Rezoning Transportation Analysis
Petition Number: Insert Zoning Petition #2021-209
General Location Identifier: 20109103

Revision Log:	Date	Description
	01-24-2022	First Review (KP)

Transportation Summary

1 REZONING PLAN

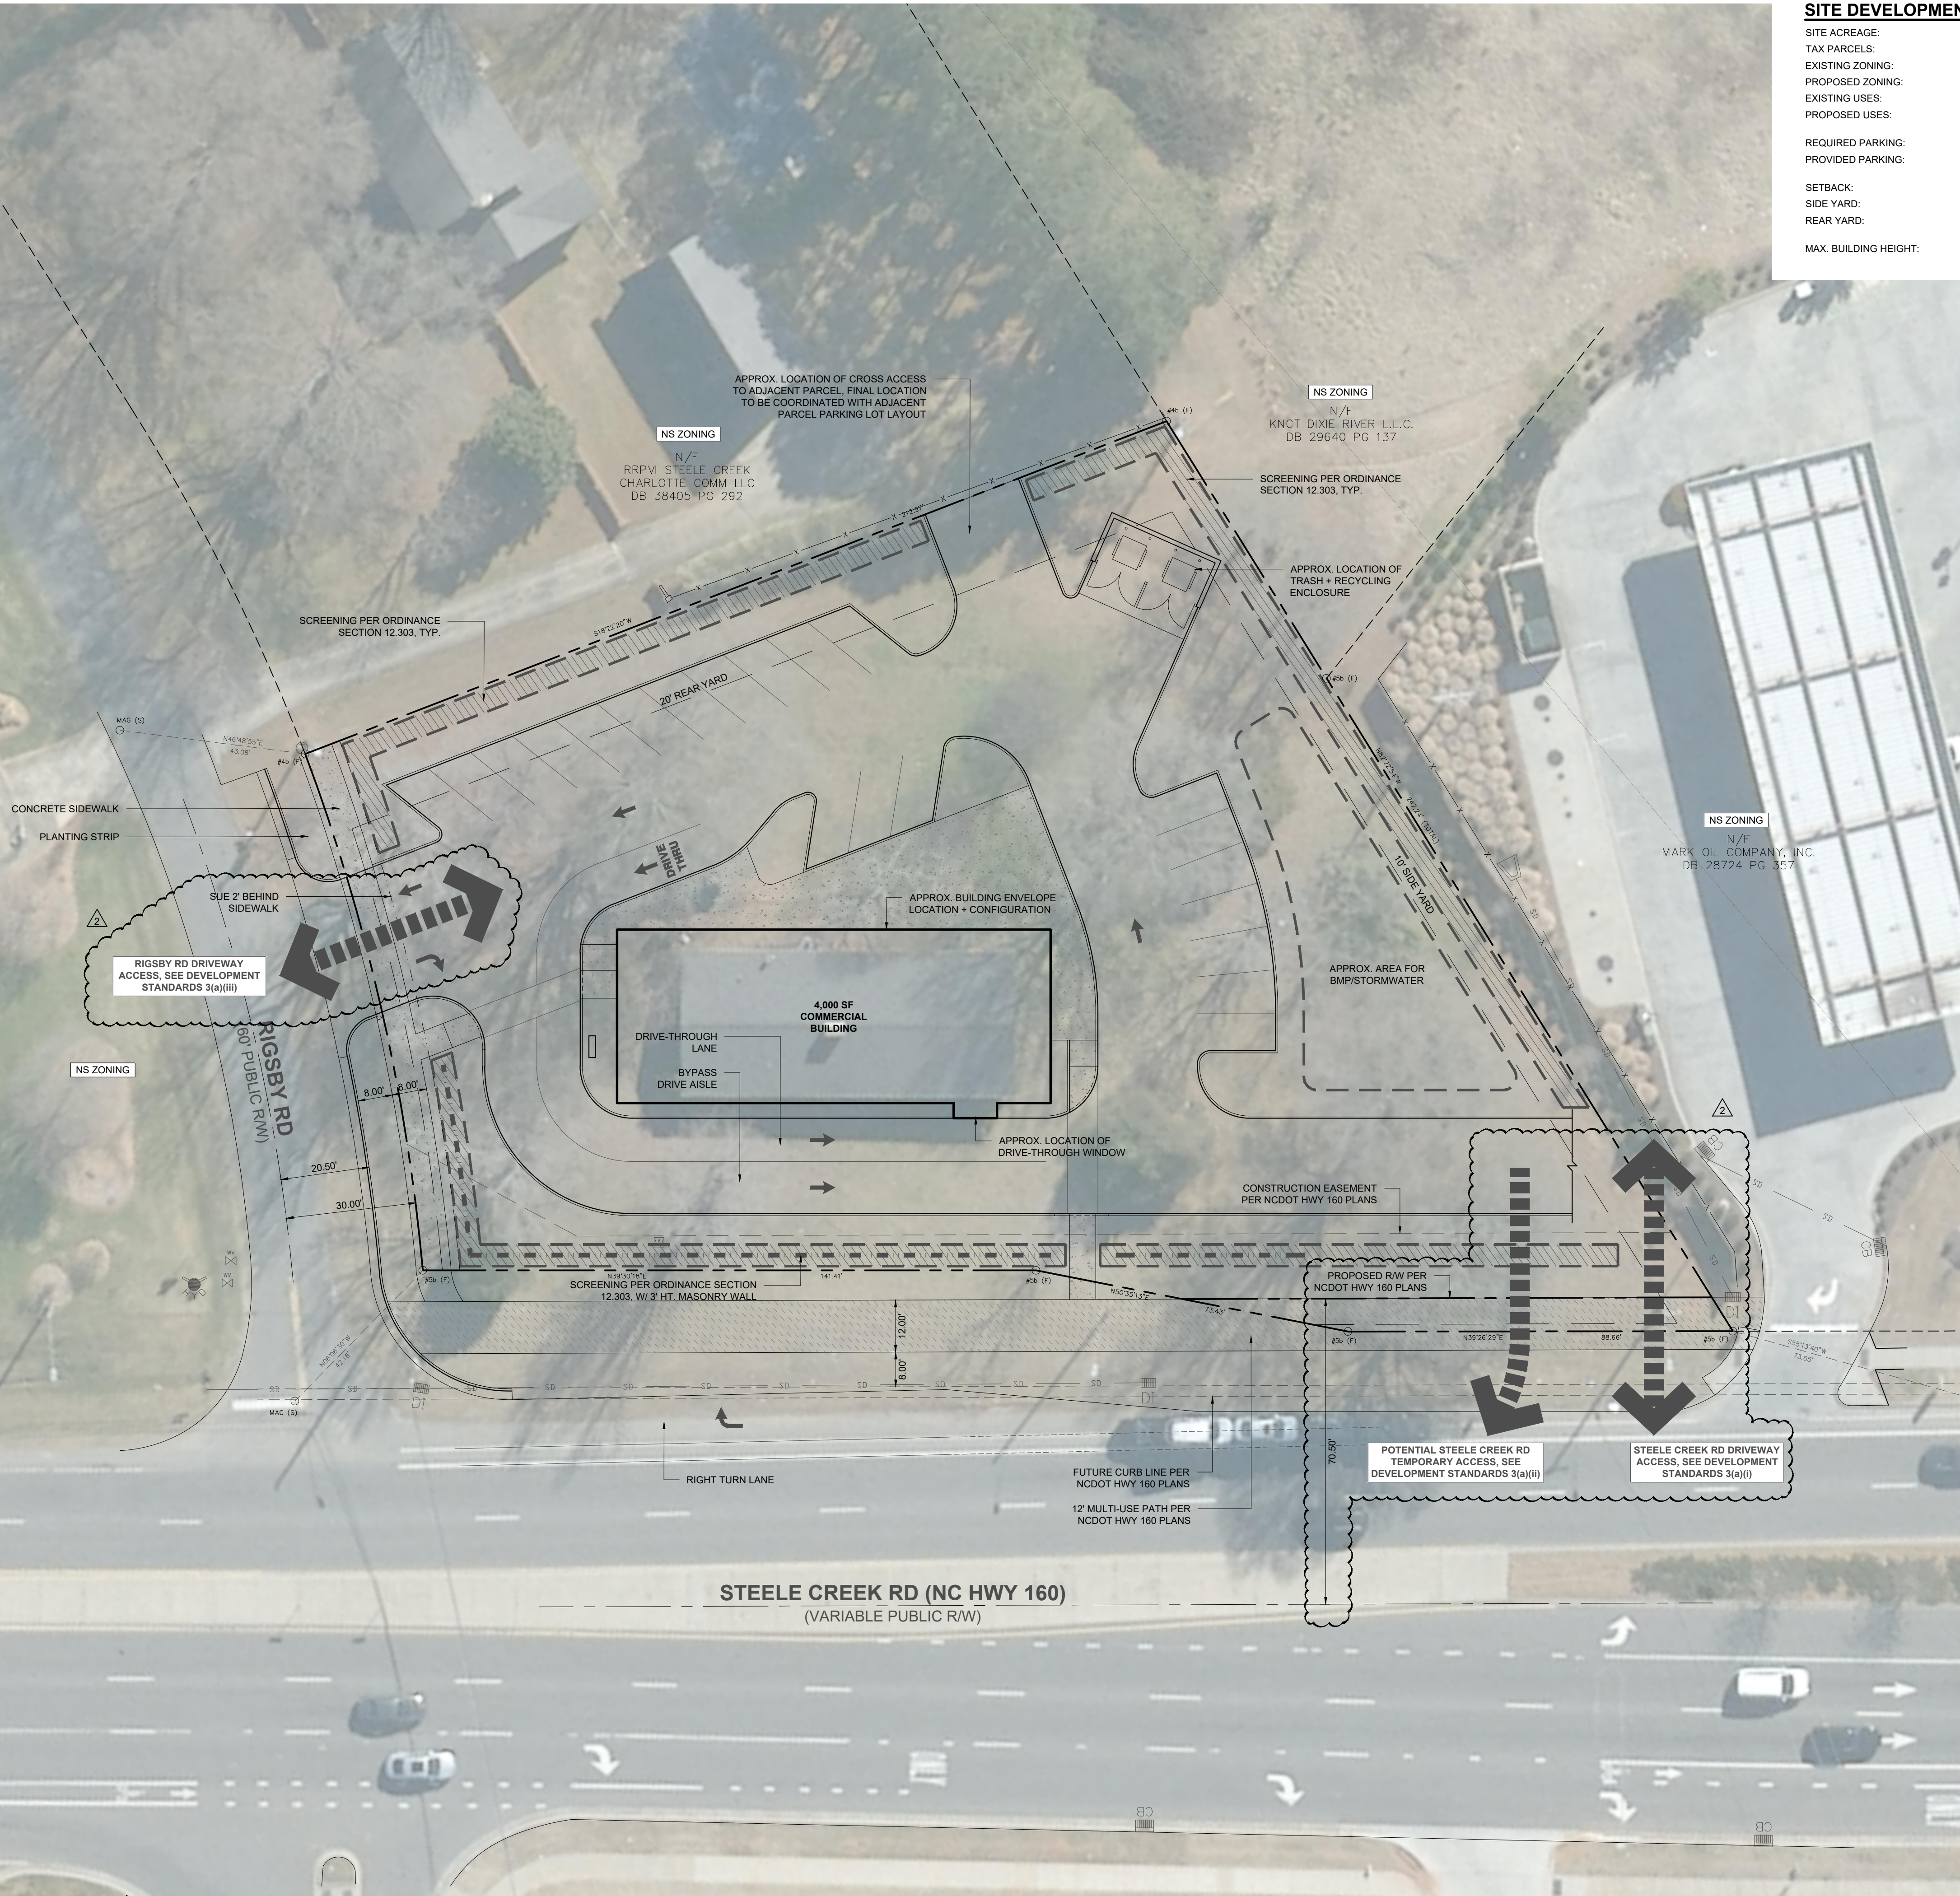
Label and dimension the back of curb and gutter from the existing centerline of each road.

- a. **Steele Creek Road:** Revise site plan and conditional note(s) to commit to dedicate the right-of-way and easements, in accordance with the typical section established in the U-5766 STIP Project, as generally depicted as on the site plan.

- b. **Rigsby Road:** Revise the site plan and conditional notes to dedicate 38.5-feet of right-of-way, in accordance with CLDSM U-05A Local Commercial Wide cross section, from the existing road centerline.

The site plan shall label and dimension the right-of-way from the road centerline.

- 4. Revise site plan and conditional note(s) to commit to construct an 8-foot planting strip and 8-foot sidewalk along the site's frontage of Rigsby Road, in accordance with CLDSM U-05A, Local Commercial Wide cross section. The site plan shall label and dimension both items from the back of curb and gutter and road centerline.
- 5. Revise site plan and conditional note(s) to commit to construct the 12-foot shared-use path along the site's frontage of Steele Creek Road, in accordance with the typical section established in the U-5766 STIP Project, as generally depicted on the site plan.

6. Revise site plan by removing the proposed right-in right-out driveway on Steele Creek Road.

7. Revise the site plan and conditional notes to commit to construct a northbound right-turn lane, on Steele Creek Road, at Rigsby Road. The storage and taper lengths will be subject to NCDOT standards and approval.

8. Revise the conditional notes to commit to provide CDOT, during permitting, a drive-thru queuing analysis for the AM and PM Peak Hours to ensure vehicle queuing does not impede access from Rigsby Road and/or impede the normal flow of traffic on Rigsby Road. Pending the results of the queuing analysis, the petitioner shall coordinate with CDOT to revise the internal site layout to accommodate for the determined drive-thru queuing.
